Rezoning Transportation Analysis

Petition Number: #2022-076

Date	Description
10-26-22	First Review (IW)
12-21-22	Second Review (IW)

Sheet
RZ-1.0

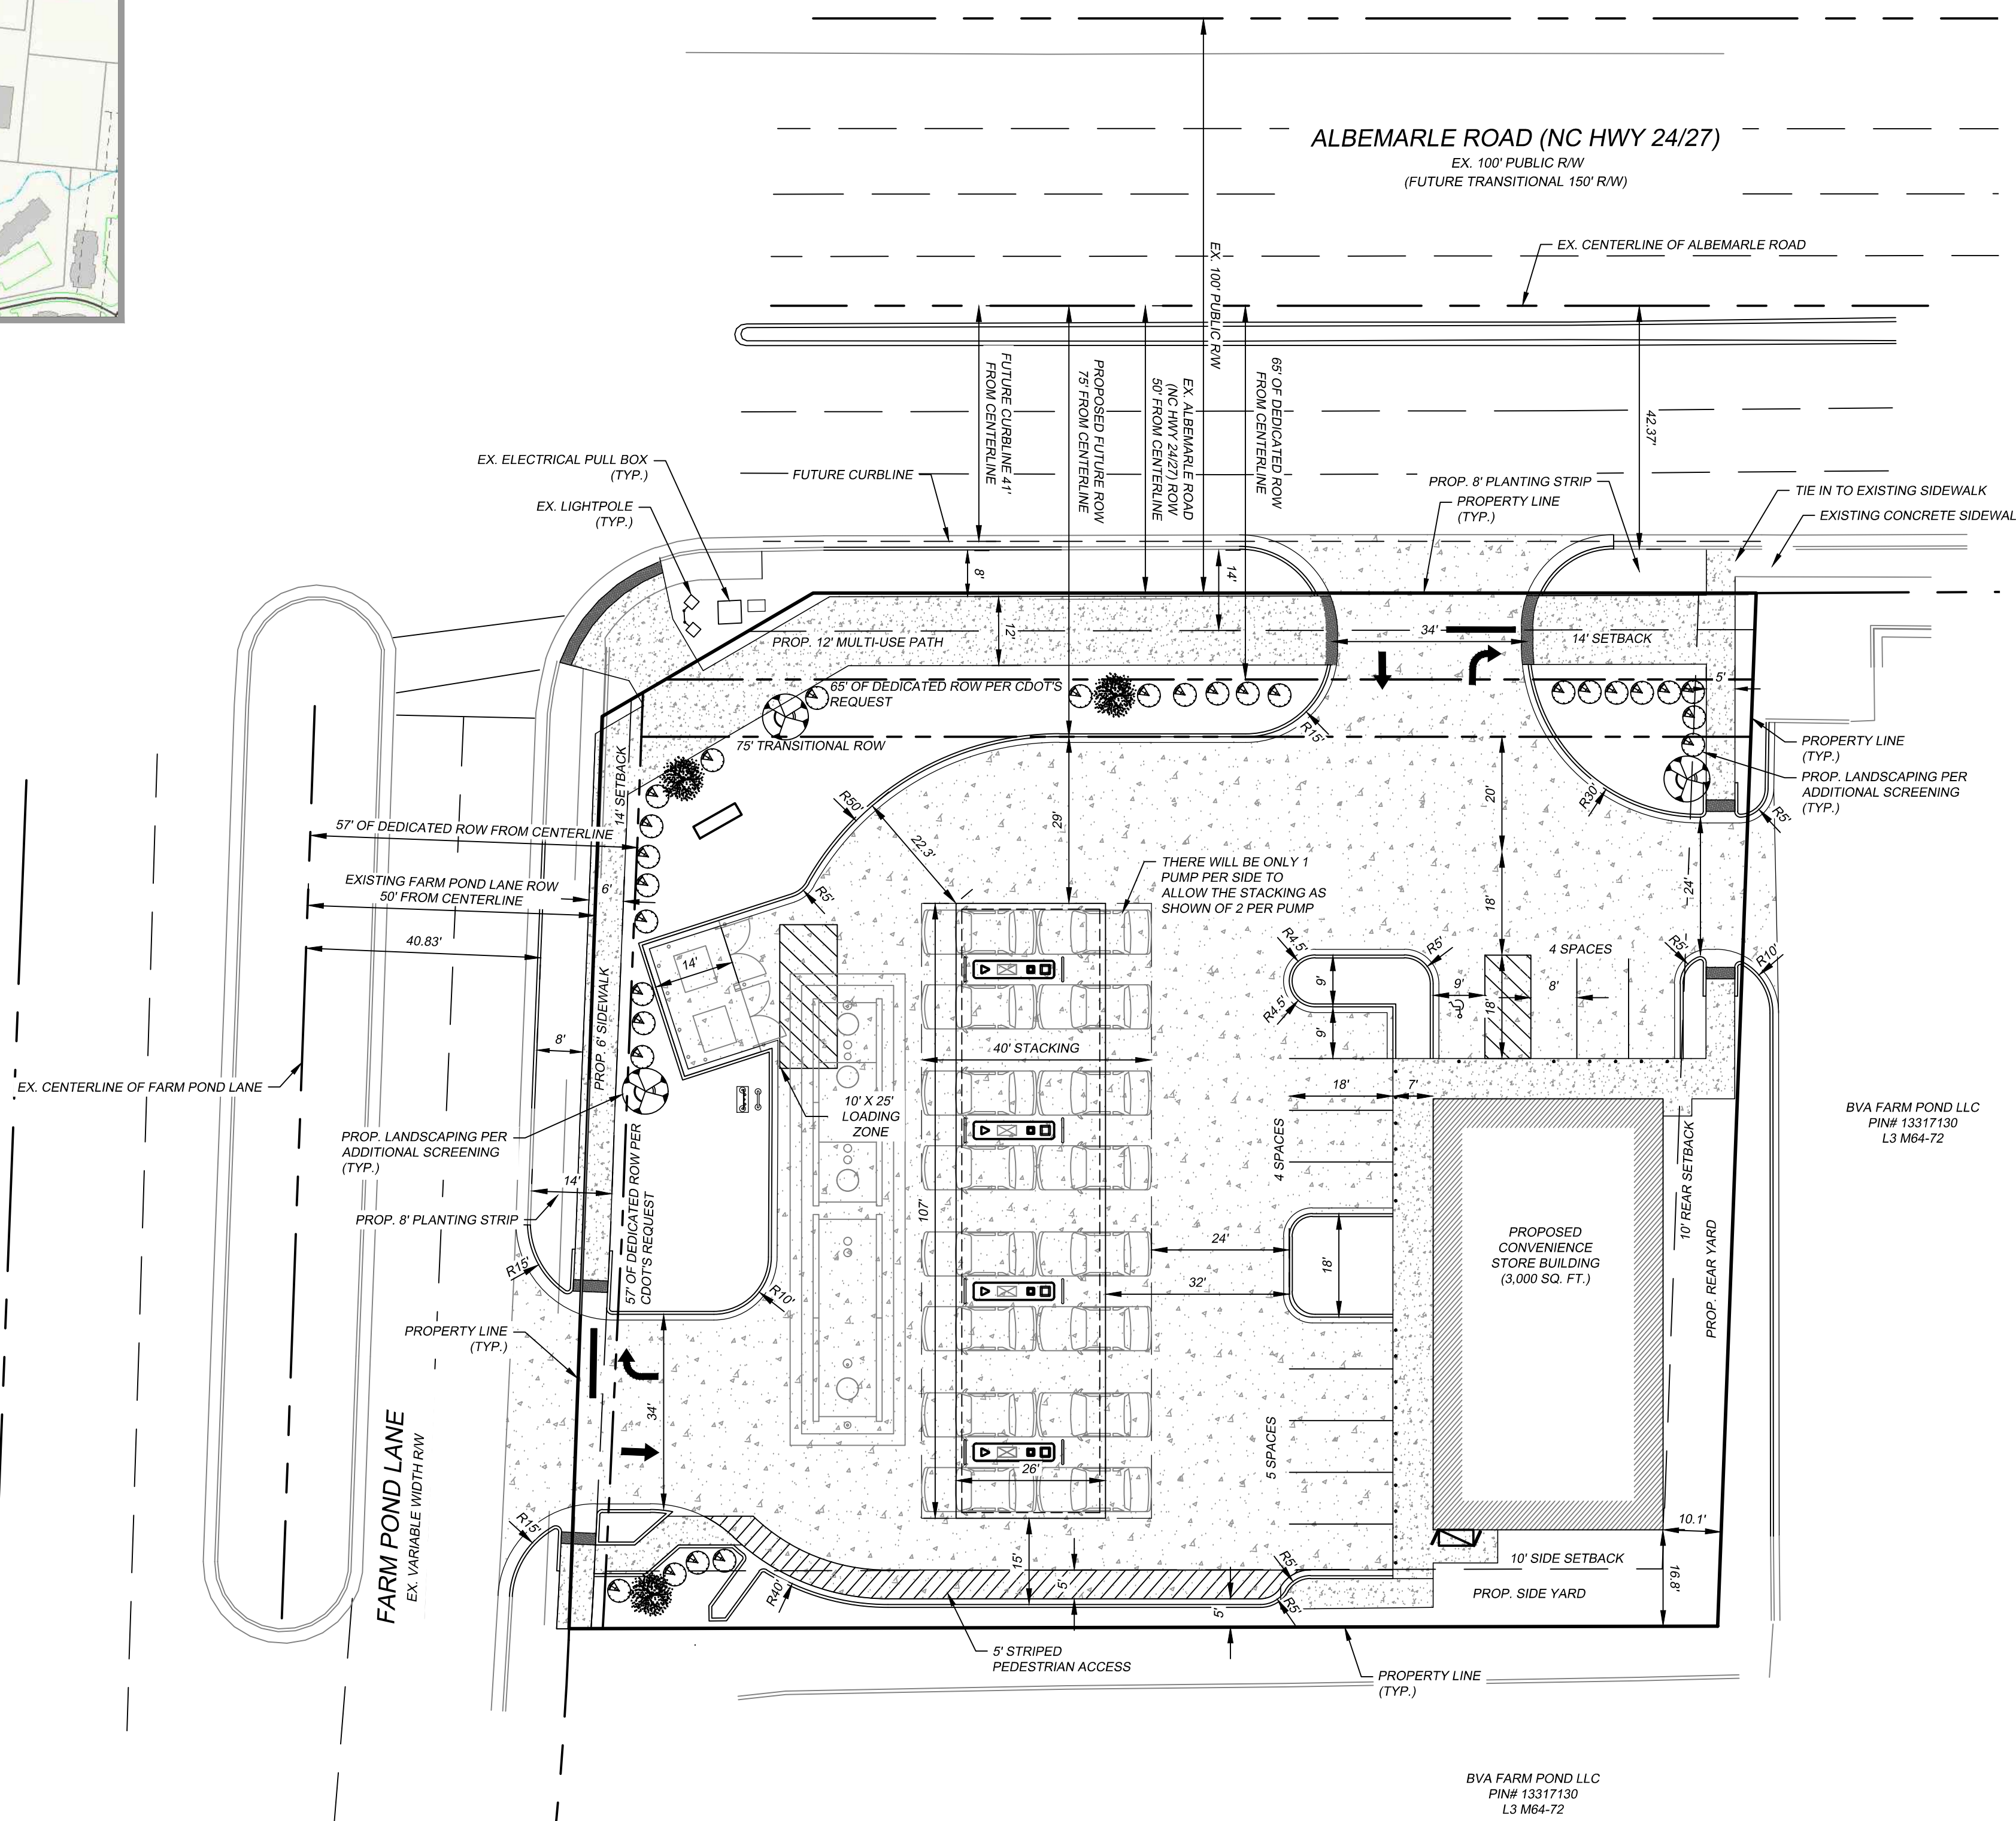
1. ~~**Curblin**~~: The proposed zoning district has a setback measured from back of the existing or proposed future curblin.
 - a. ~~**Albemarle Road**~~: Future curblin location: 41' from centerline of Albemarle Road
 - b. ~~**Farm Pond Ln**~~: Maintain existing curblin

Label and dimension the curb and gutter from the centerline for each road on the site plan.

3. ~~Revise site plan and conditional note(s) to commit to dedicate 63' right-of-way from the road centerline on Albemarle Road (or 2' behind proposed 12-foot multi-use path). Revise site plan to label and dimension existing right-of-way from centerline of Farm Pond Lane and/or committing to dedication of right-of-way set 2' behind proposed sidewalk where feasible.~~

~~The site plan shall label and dimension the right-of-way from the road centerline for both roadways.~~

4. ~~Revise site plan and conditional note(s) to commit to construct an 8-foot planting strip and 6-foot sidewalk on Farm Pond Road per Chapter 19. Revise site plan and conditional note(s) to commit to construct an 8-foot planting strip and 12-foot Multi-Use Path on Albemarle Road per Chapter 19 and the city council adopted future Charlotte Streets Map.~~

~~The site plan shall label and dimension both items from the back of curb and gutter and road centerline.~~

5. ~~Petitioner to revise site plan and conditional notes to show and commit to improving ramps at their corner of Albemarle Road and Farm Road Lane to comply with ADA/PROWAG standards. Per federal ADA guidelines, ramps should match width of sidewalk. 12 feet on Albemarle and 6 feet on Farm Pond Road.~~
